**MODIFICATION REQUEST:
61 Mobbs Lane, Epping (Former Channel 7
Site)
(MP 10_0107 MOD 3)
Minor Design Changes to Building 2**

Director-General's
Environmental Assessment Report
Section 75W of the
Environmental Planning and Assessment Act 1979

February 2012

DRAWING TITLE: B2 ELEVATIONS

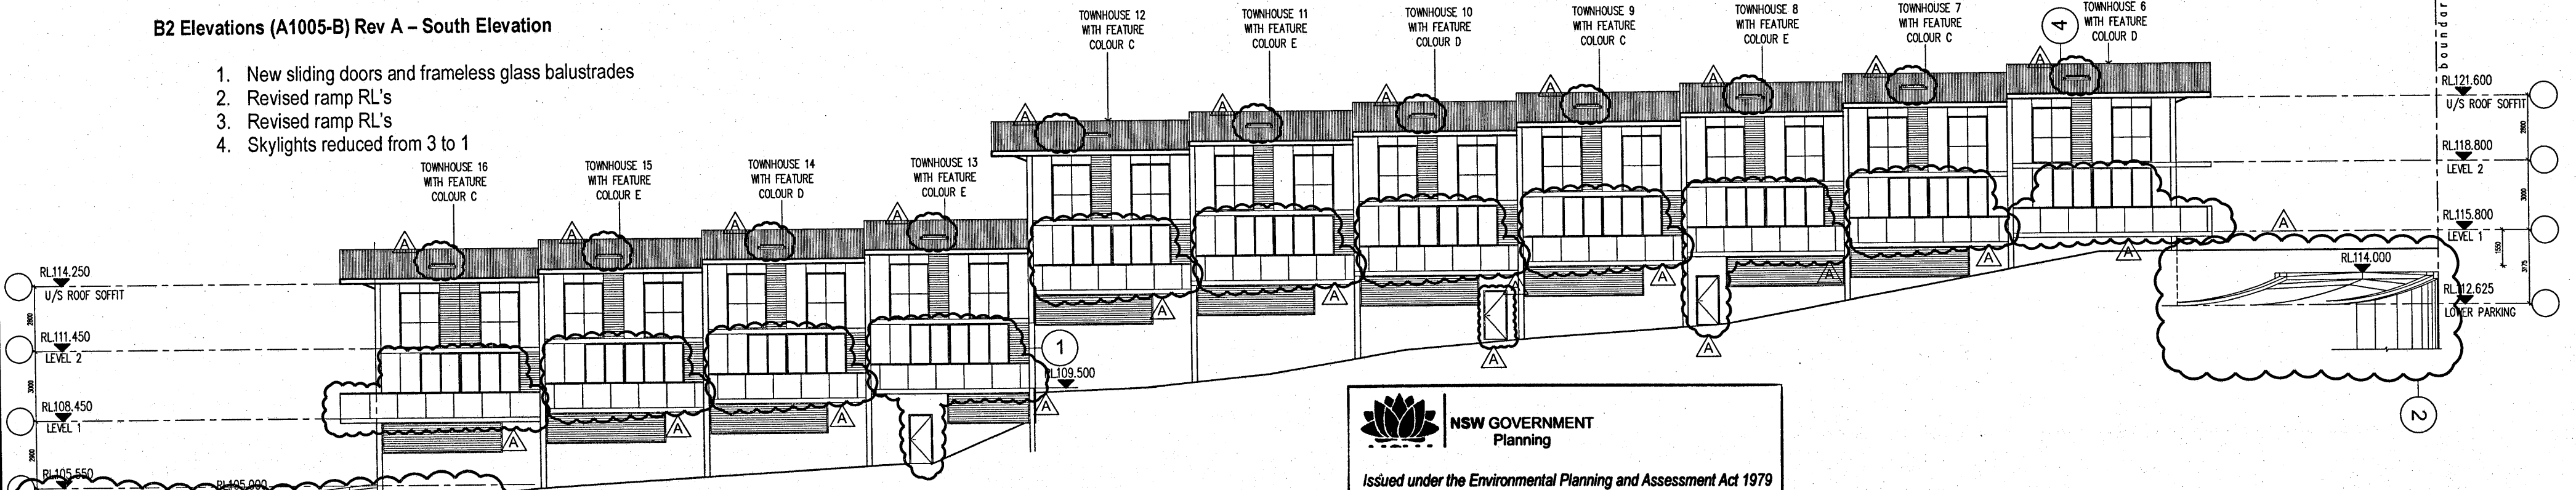
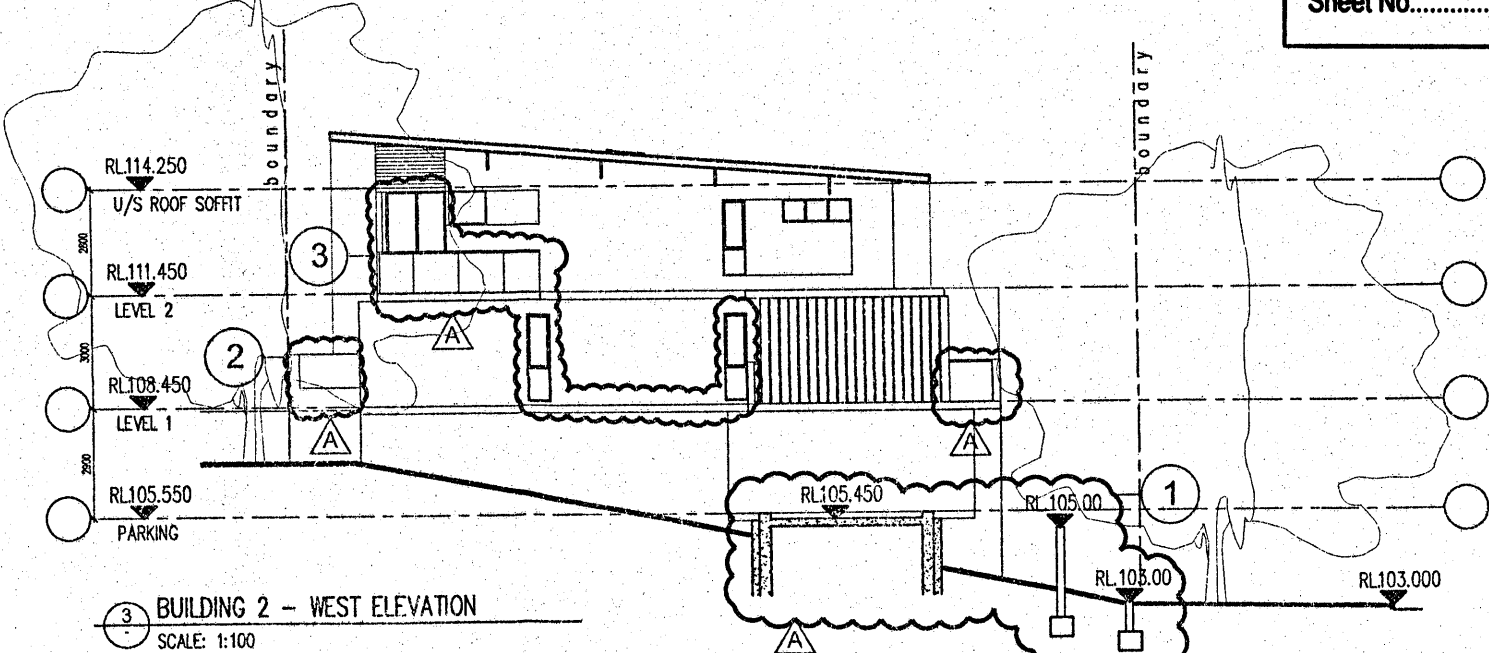
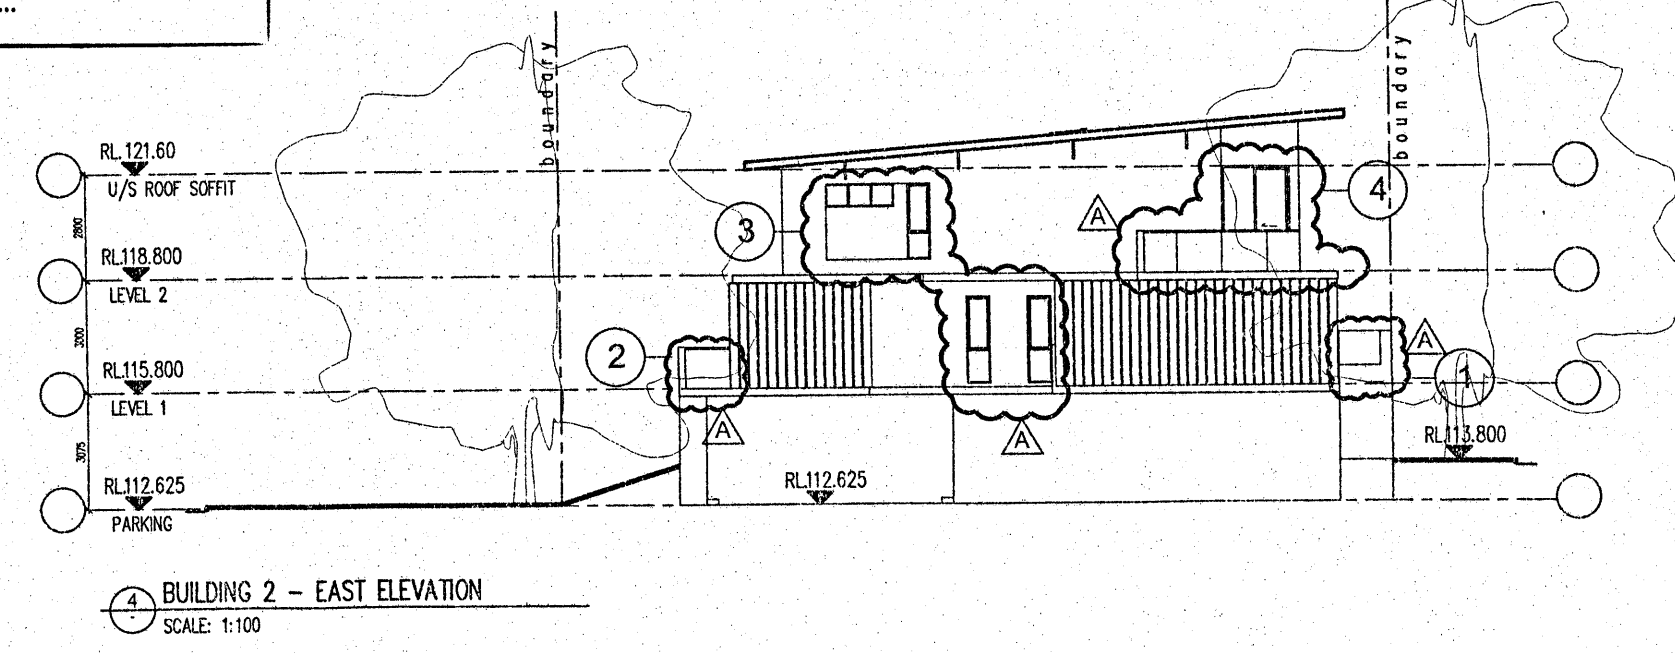
The proponent has identified inconsistencies between the approved floor plans and the elevations for building 2 (drawing numbers A1005-B and A1003-D). As previously stated, these inconsistencies relate to the exclusion of an upper level balcony on the southern elevation of townhouse 16, and the incorrect positioning of windows on the eastern elevation of townhouse 6. Diagrams identifying the inconsistencies between the approved floor plans and elevations, and how these will be rectified via the submission of revised plans are provided at **Figures 6 and 7** overleaf.

Comment: The department is satisfied that there are no inconsistencies between the approved floor plans and the revised elevations. In addition, the department considers that

the revisions proposed to the eastern elevation of townhouse 6 would not result in any unacceptable privacy impacts at townhouses 5 or 6 given that:

- the extent of glazing is generally consistent with the original project approval, and the use of the rooms along the eastern elevation of building 2, and the western elevation of building 1 remain unchanged
- there is a 33 m setback between townhouses 5 and 6. This exceeds the minimum 12 m setback recommended to maintain privacy between two habitable rooms in the Parramatta Development Control Plan 2011, and the Residential Flat Design Code.

Given the above, the department considers that the modifications proposed to rectify the inconsistencies between the approved floor plans and elevations are acceptable.
